7000 Acres Response to the Cottam Solar Project Ltd Application on the subject of:

Agriculture & ALC

Deadline 1 Submission – 17th October 2023

Appendix 1 - Cottam 1a

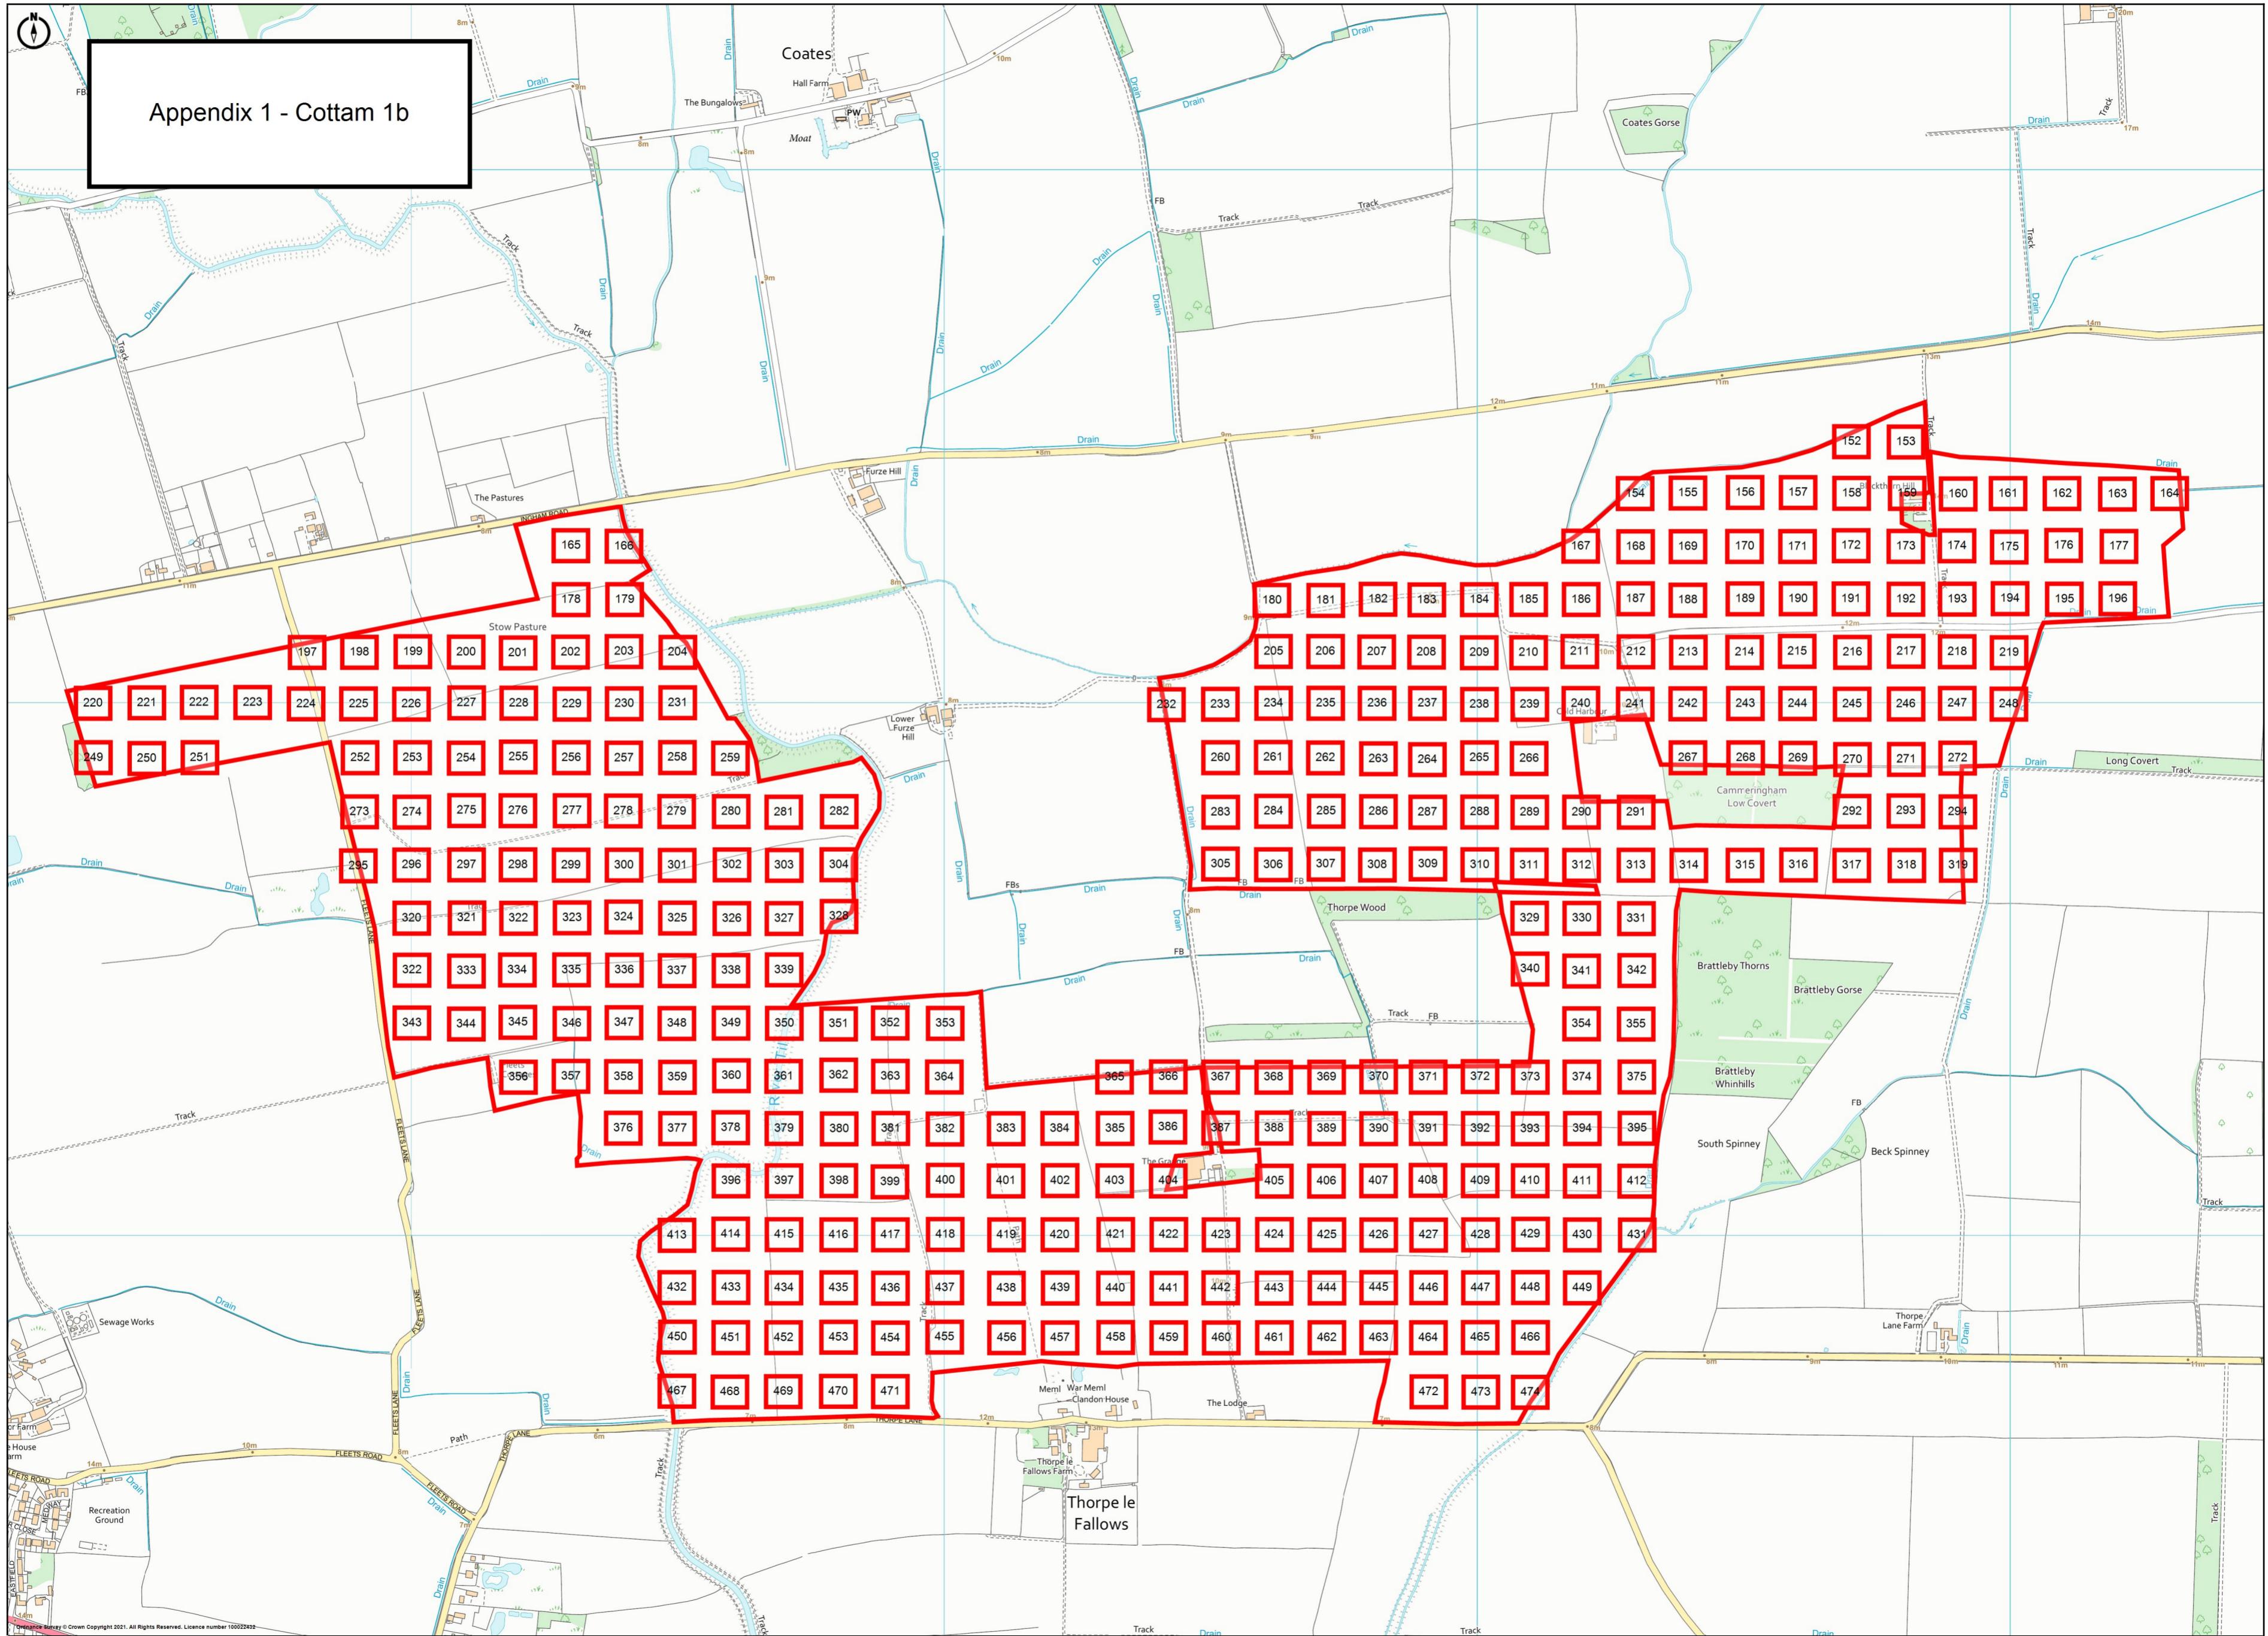
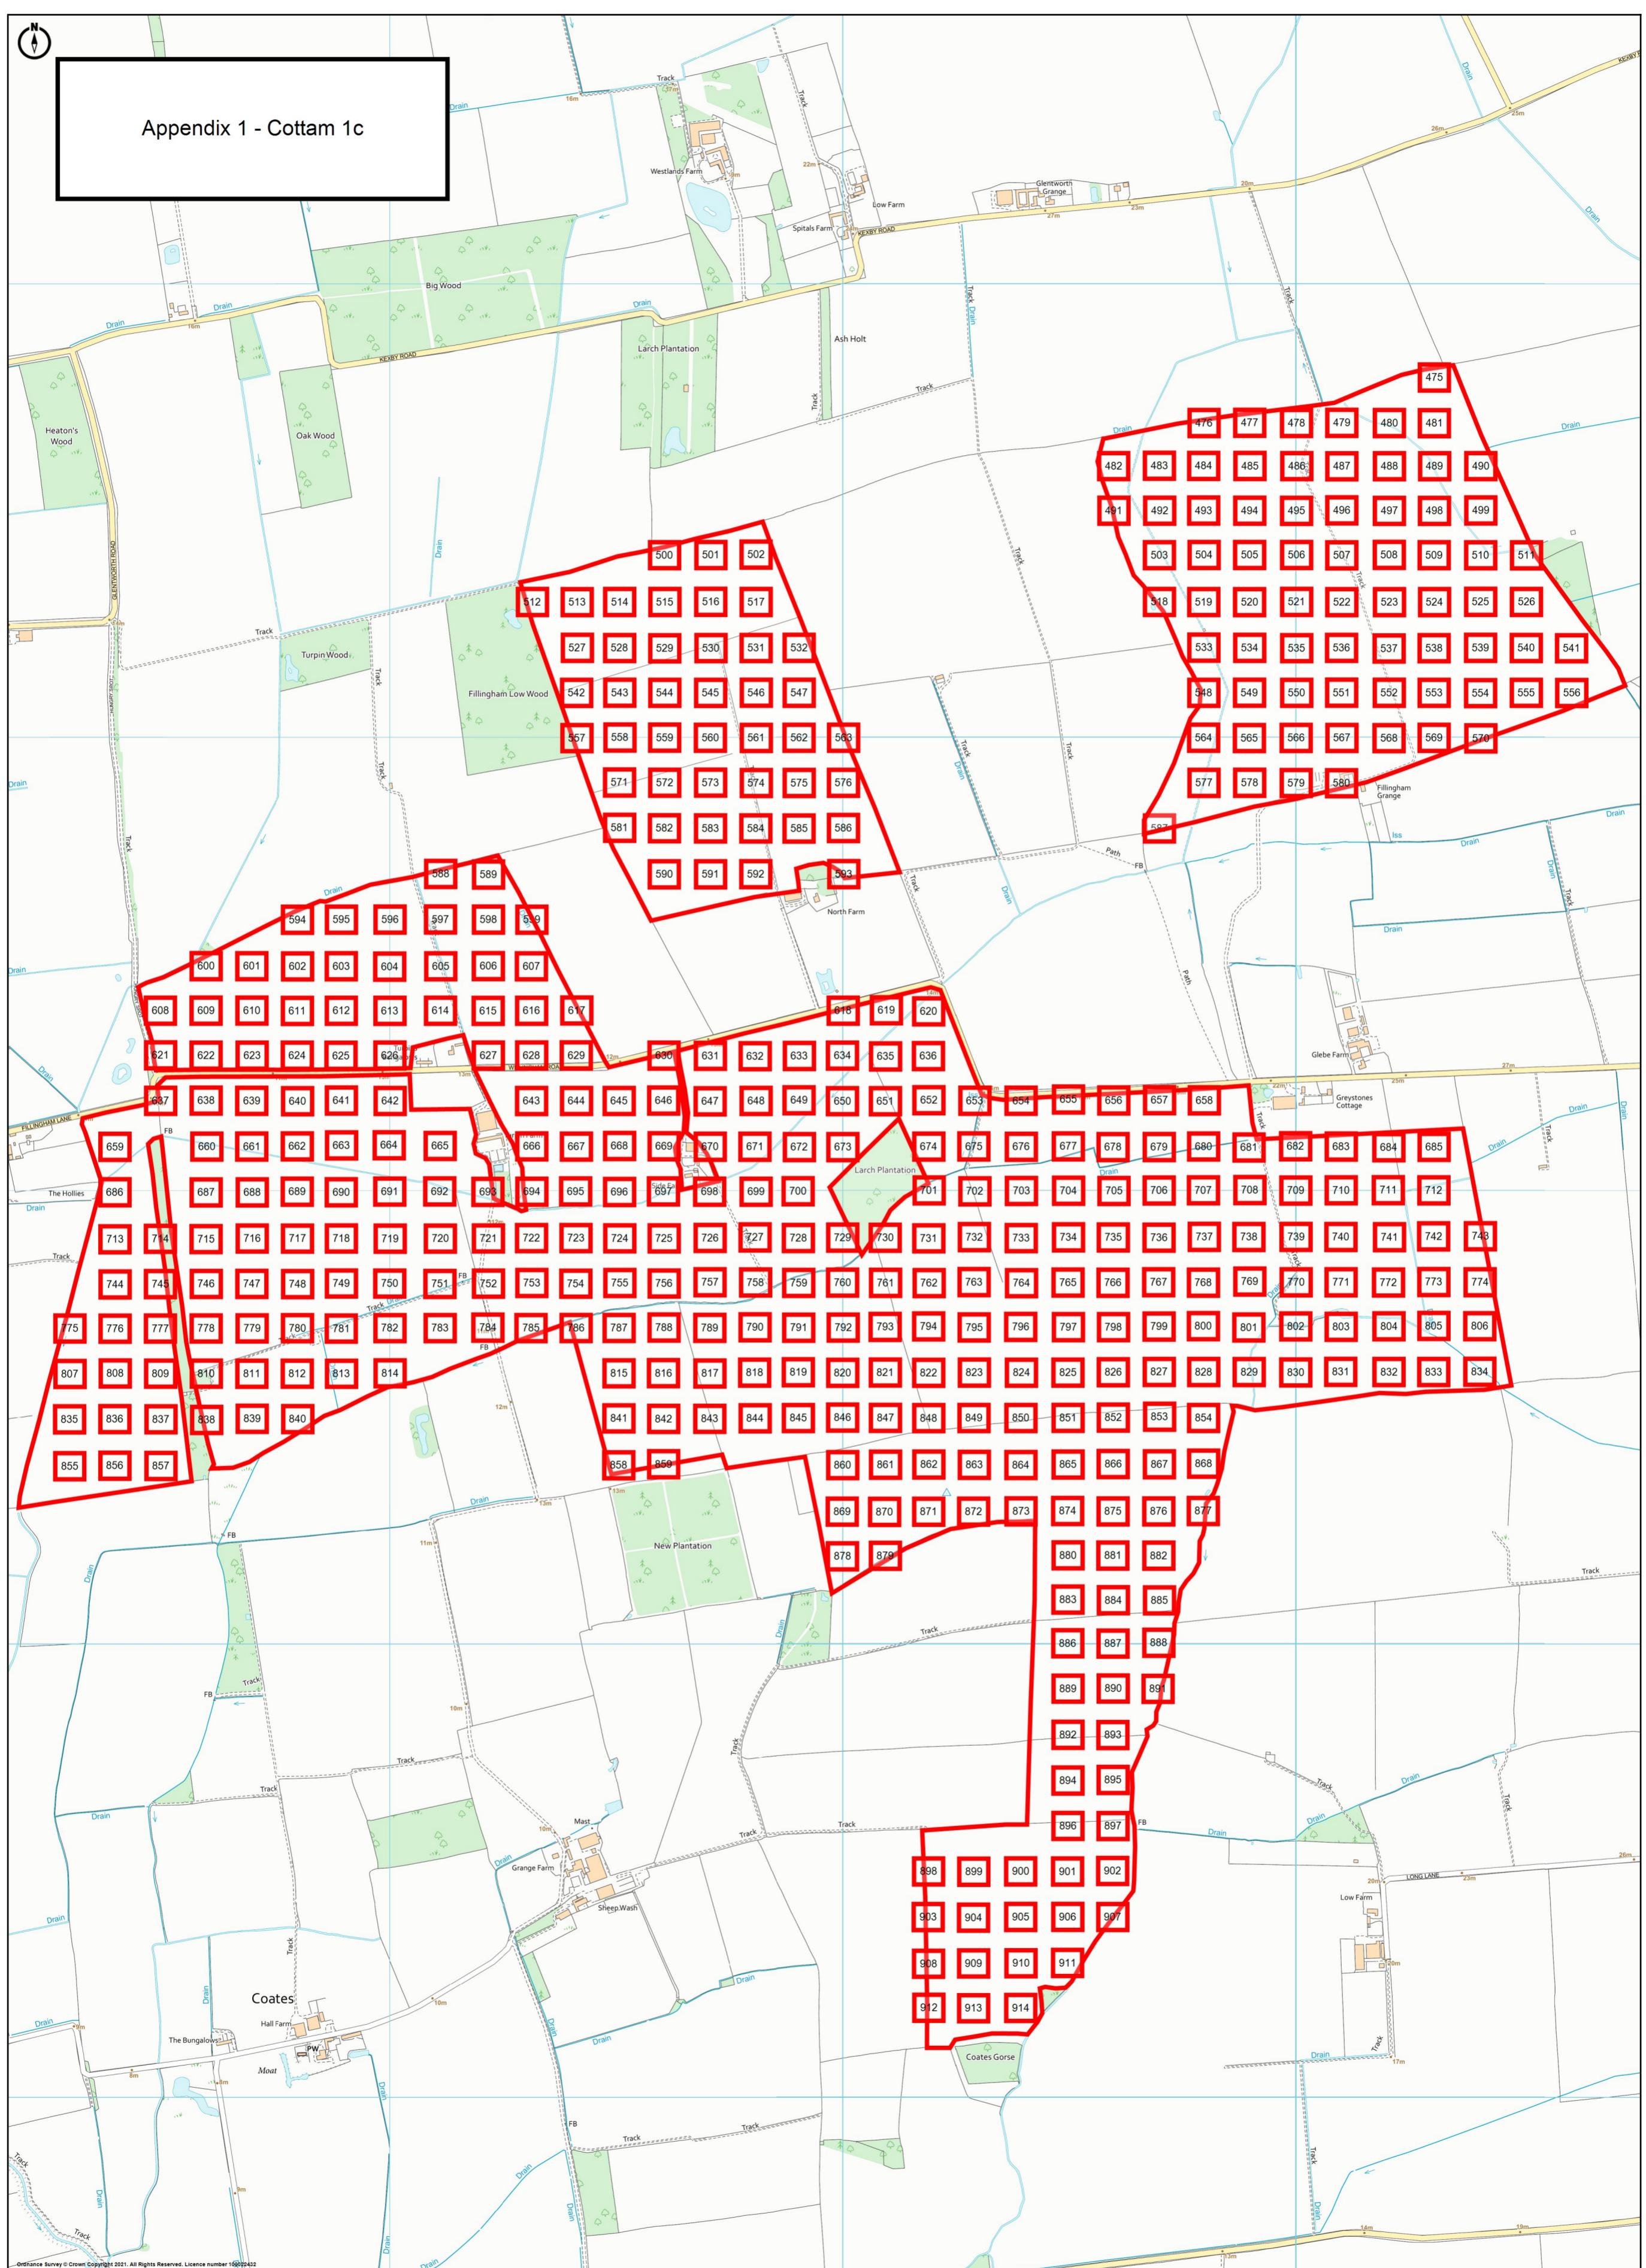
Detailed analysis of the EN010133-000195-C6.3.19.1 ES Appendix 19.1 Agricultural Land Quality Soil Resources and Farming Circumstances Report prepared by Daniel Baird Soil Consultancy Ltd (Baird Soil) January 2023 identifies site survey results prepared by two companies for the Cottam Solar Project, namely a report by James Fulton MRICS FAVV of AMET Property dated 12th July 2022 for surveys of Cottam 1, 2 and 3 carried out in September, October and November 2021 and one by F.W Heaven BSc, MISoilSci of Land Research Associates Ltd dated 19th September 2021 for surveys of Land near Blyton

(Cottam 3b) carried out in September 2021. Within the AMET report a number of anomalies and inconsistencies are evident. Namely on page 1 of Appendix 3a records 8, 9, 21 and 35 the data for Subsoil 3 Mottles and Structure have been entered into the wrong columns. This makes one question whether this data has been actually analysed or just entered into this report as pictorial evidence because it is a requirement.

The second element of question is more important as survey result 1090 has been assessed as being Grad 3a, while 1121 has been assessed as being Grade 3b despite the survey results being exactly the same. This inconsistency in the analysis of the results needs to be explained.

Within the Land Research report there are 6 occurrences where the grade has been assessed as 3a/3b. An experienced assessor would have understood the importance of making a judgement decision erring on the better grade as a result.

It also questions the reported area shown in Table 1 Areas occupied by the different land grades when you add in all of the grade 2, 3a and 3a/3b observations and why did they omit grade 2 in their table.
